TfNSW reference: WST24/00162/002, SF2024/083093

SSD-55968733 – Burroway Solar Farm – Lot 40, DP752577, 1955 Eumungerie Road, Burroway – TfNSW response to the Environmental Impact Statement

Transport for NSW (TfNSW) is responding to the exhibition of the Environmental Impact Statement (EIS) for SSD-55968733 for Burroway Solar Farm referred via the Major Projects Portal on 11 October 2024. TfNSW have reviewed the EIS and the Traffic Impact Assessment (TIA) prepared by Amber Organization dated 20 July 2023 as key reports in formulating this response.

Figure 4: Turning Movement Count Peak Hour Survey Results

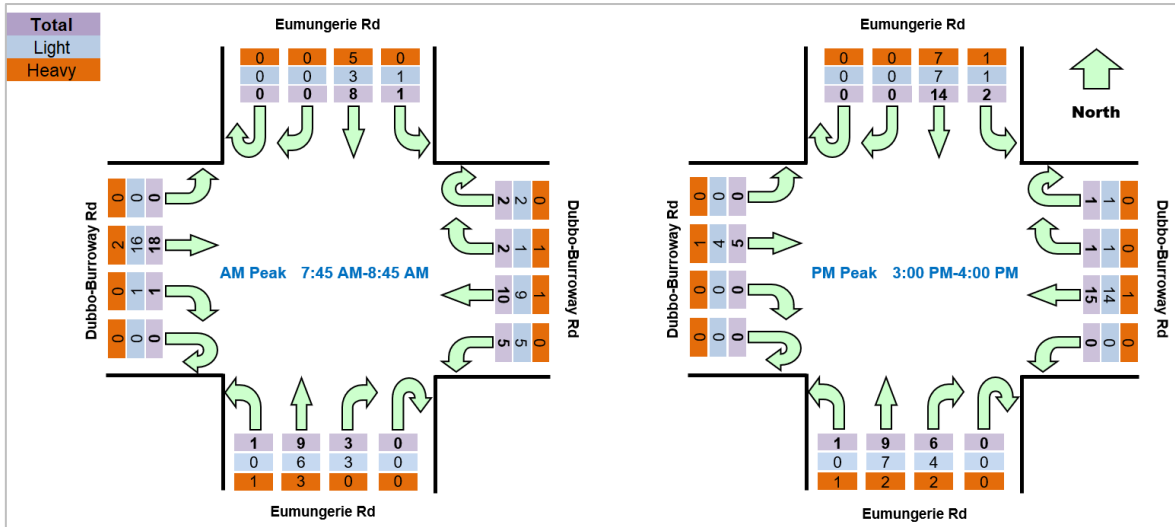
- c) Application of annual growth applied linearly to the peak of construction.
- d) Traffic count survey was collected on a single day in May 2023, which isn't reflective of the worst-case scenario for the network AM/PM peak hour which occurs during the harvest period. Traffic data is to be obtained or collected for the harvest period fluctuation for the Eumungerie Road/Newell Highway intersection and compared to the existing traffic assessment. Any recommendations to minimise the projects traffic impact during this period will need to be included within the revised TIA.

Figure 17: Access Route from Port of Newcastle to Site

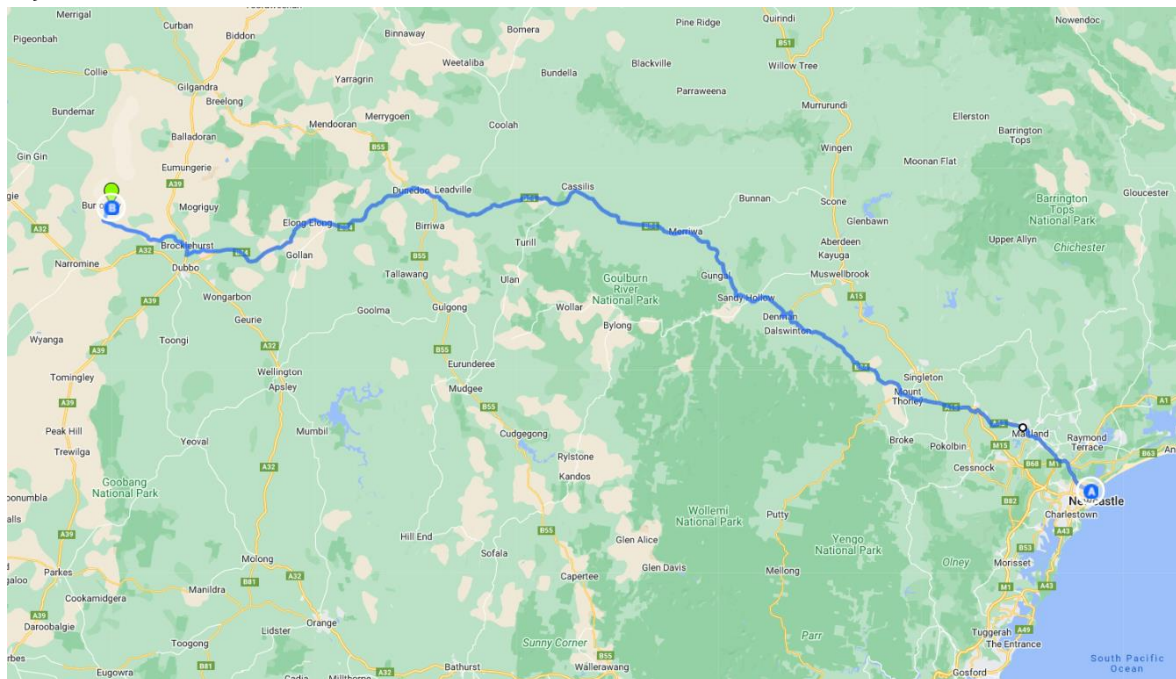
1. The TIA has not included a Concept Level Route Analysis (high risk OSOM (as defined on TfNSW website)). This analysis must include:
 - a) The port or point of origin and must be for the entire route to the site access or intersections required to facilitate the high risk OSOM movements required for the project.

- b) The TIA is required to include details of all high risk OSOM loads and vehicle configurations for the project.
 - c) The location of pull-over bays / rest areas along the high risk OSOM routes (including GPS coordinates) and demonstrate through swept paths that the high risk OSOMs can be physically accommodate all high risk OSOMs for the project (in terms of size, width and accessibility).

- d) Details of the road geometry and alignment along the identified transport route/s, including existing formations, crossings, bridges, intersection treatments; and any pinch points along the routes such as bridges, culverts, traffic signals, signage, roundabouts, medians, and vegetation. Mitigation measures or road upgrades must be identified for each pinch point.

- g) Consideration of how the high-risk OSOM will move through TfNSW projects that are currently under construction or will be completed, when the high-risk OSOM movements will be required to be moved from the Port of Newcastle to site. This is required to assess the viability and any modification to the road environment that may be required to move the high-risk OSOM via this route. The projects to be assessed, but not limited to, are the Pacific Motorway extension to Raymond Terrace and the Hexham Straight Project. Details on these projects are available on the TfNSW project websites.

- h) Consideration of road upgrades provided by EnergyCo from the Port of Newcastle to Elong Elong. The applicant must review pavement extents and the scope of works to ensure configurations and swept paths for this project’s high-risk OSOM align with the scope of the Port to Renewable Energy Zone (P2R) project, particularly the relocation of traffic signals at the George Street, Industrial Drive and Maitland Road intersections. An assessment of consistency with the P2R project must be included.

- i) The refugee island at Bettington Street / Vernacher Street Merriwa is located on a state classified road (Golden Highway). TfNSW requires the scope of works in the form of a strategic concept design identifying the removal of the refugee island and evidence of consultation with Upper Hunter Shire Council.
